Working Draft Additional Environmental Commitments

This document collates the additional environmental commitments that were presented by TII to the MetroLink Oral Hearing.

2. Additional Commitments for the Project Design (Chapter 4 of the EIAR)

ML1-JA-BOR-ROUT\_XX-DR-Y-01012

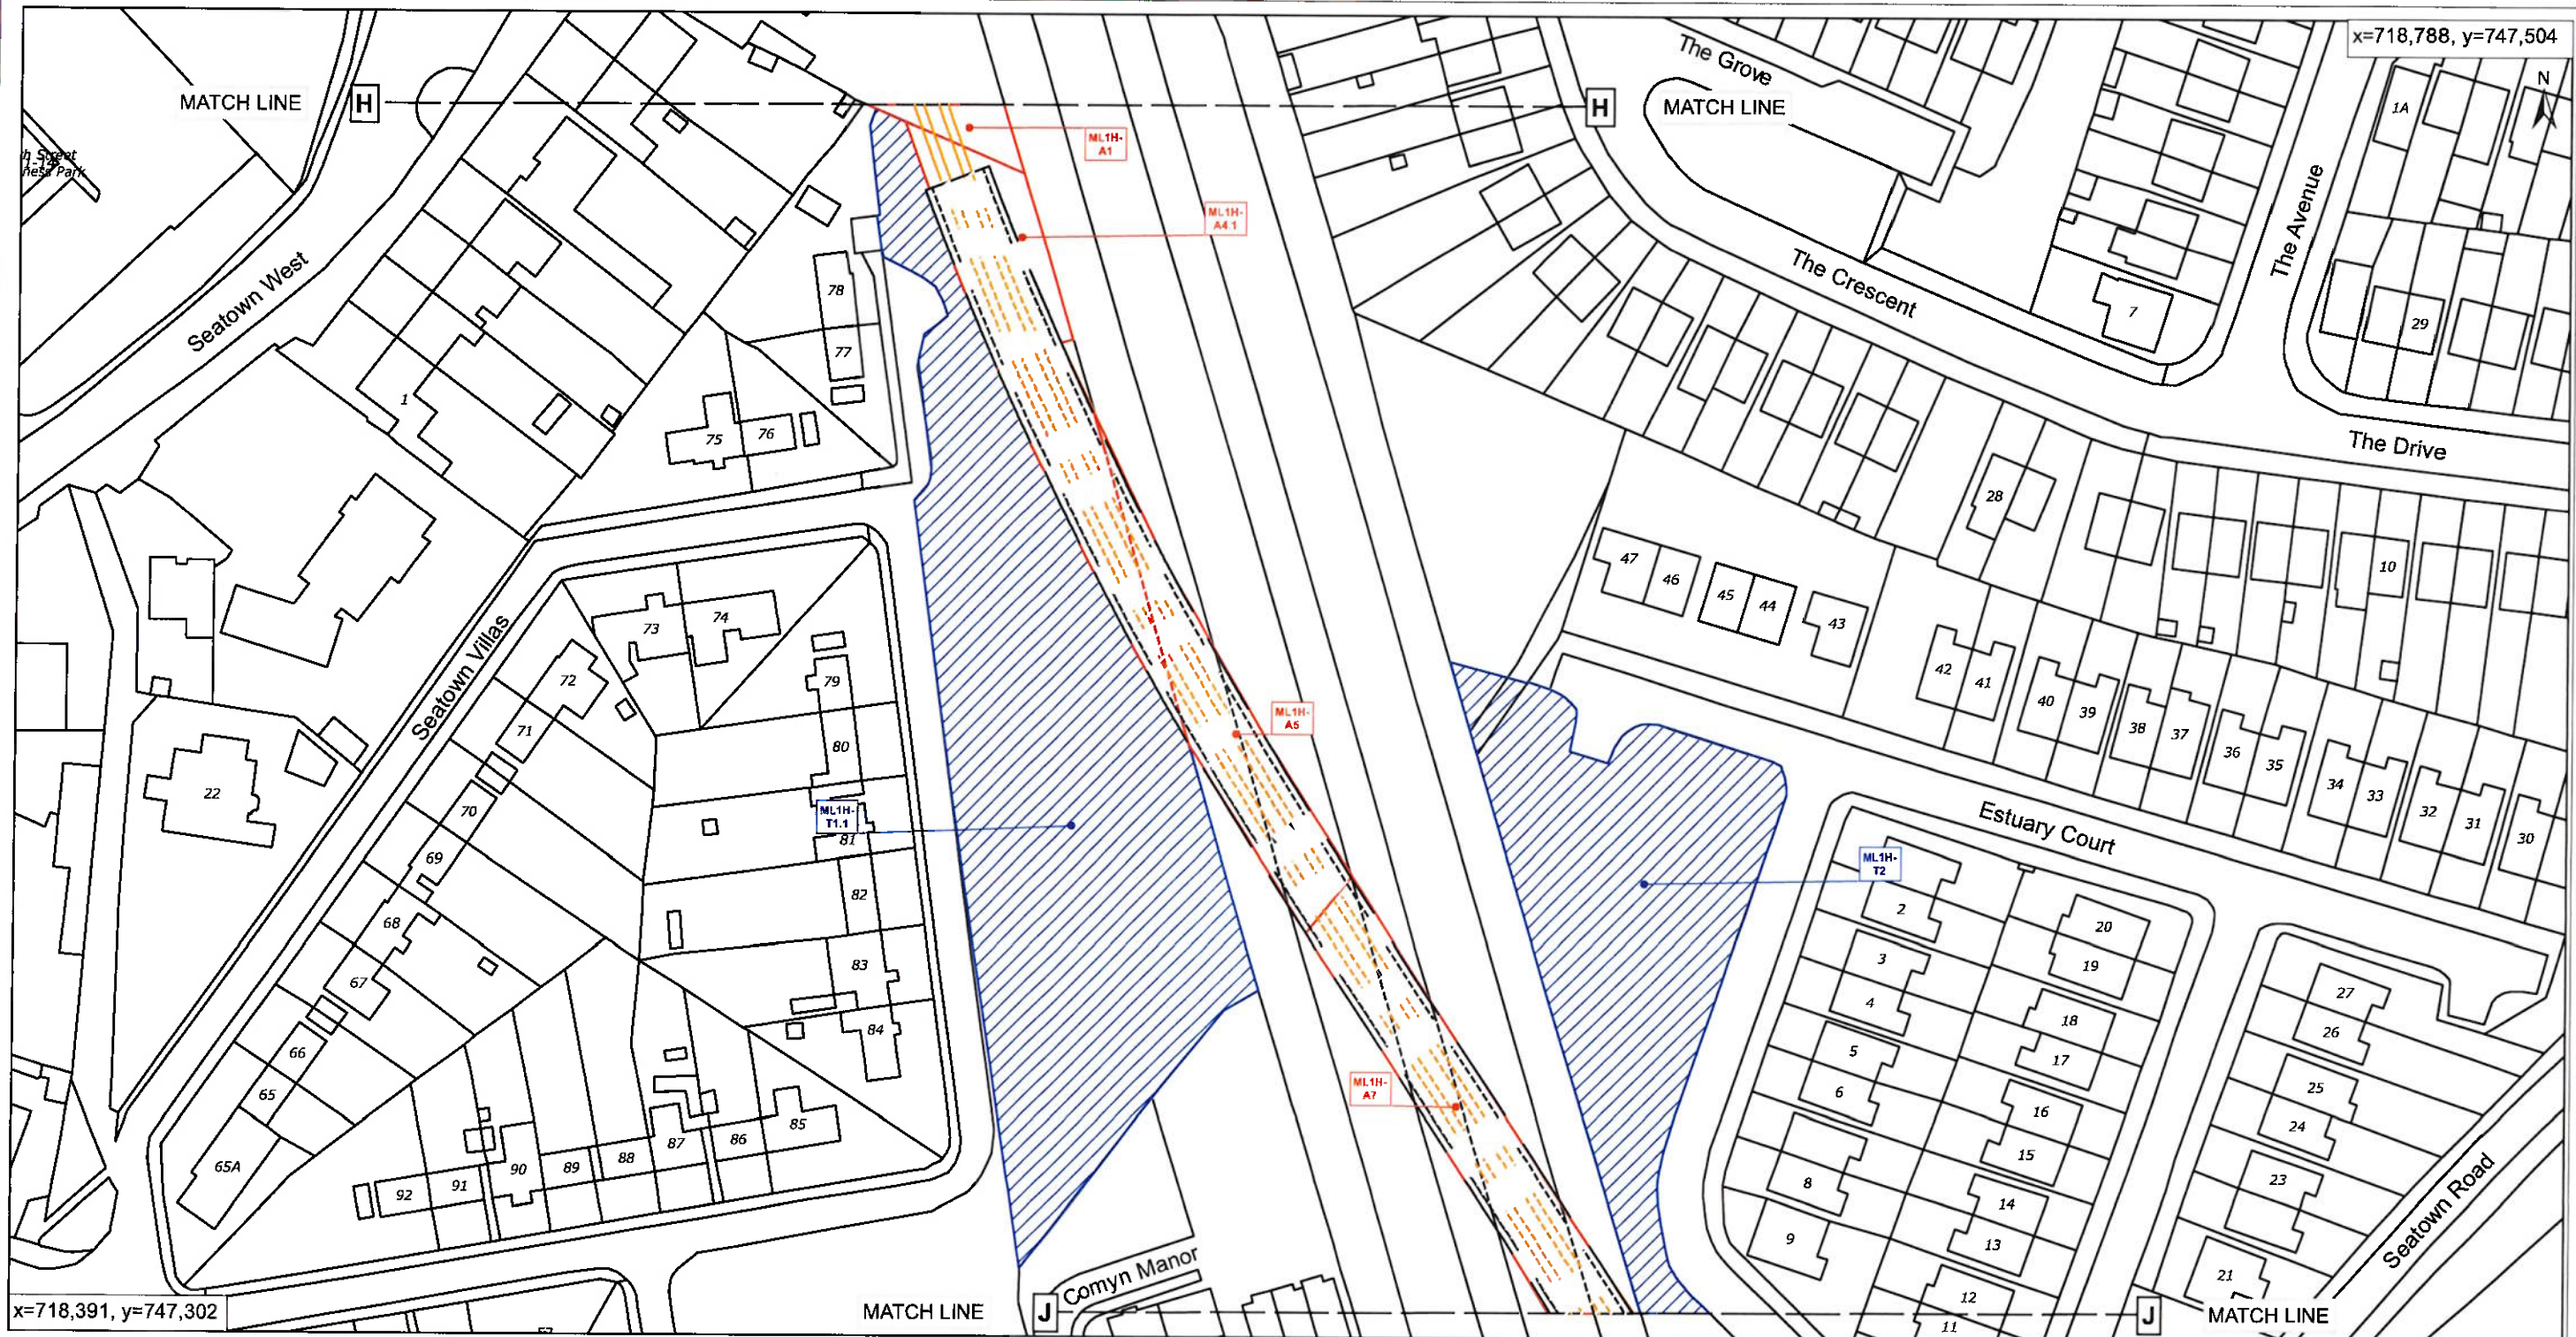
Reference	Additional Environmental Commitment	Location	RO Drawings, Errata or Update Documents
			ML1-JAI-ARL-SC01_XX-DR-Y-00002 "ML1-JAI-ARL-SC01_XX-DR-Y-00003 ML1-JAI-URD-ROUT_XX-DR-Y-02011 ML1-JAI-URD-ROUT_XX-DR-Y-02012 ML1-JAI-URD-ROUT_XX-DR-Y-01011 ML1-JAI-URD-ROUT_XX-DR-Y-01012 ML1-JAI-BOR-ROUT_XX-DR-Y-01012
2.7	Replacement of approximately 50m retained open cut south of Pinnockhill roundabout with cut and cover tunnel and revisions to property access.	Pinnock Hill	ML1-JAI-ARD-ROUT_XX-DR-Y-03022 ML1-JAI-ARL-SC03_XX-DR-Y-00006 ML1-JAI-URD-ROUT_XX-DR-Y-01022
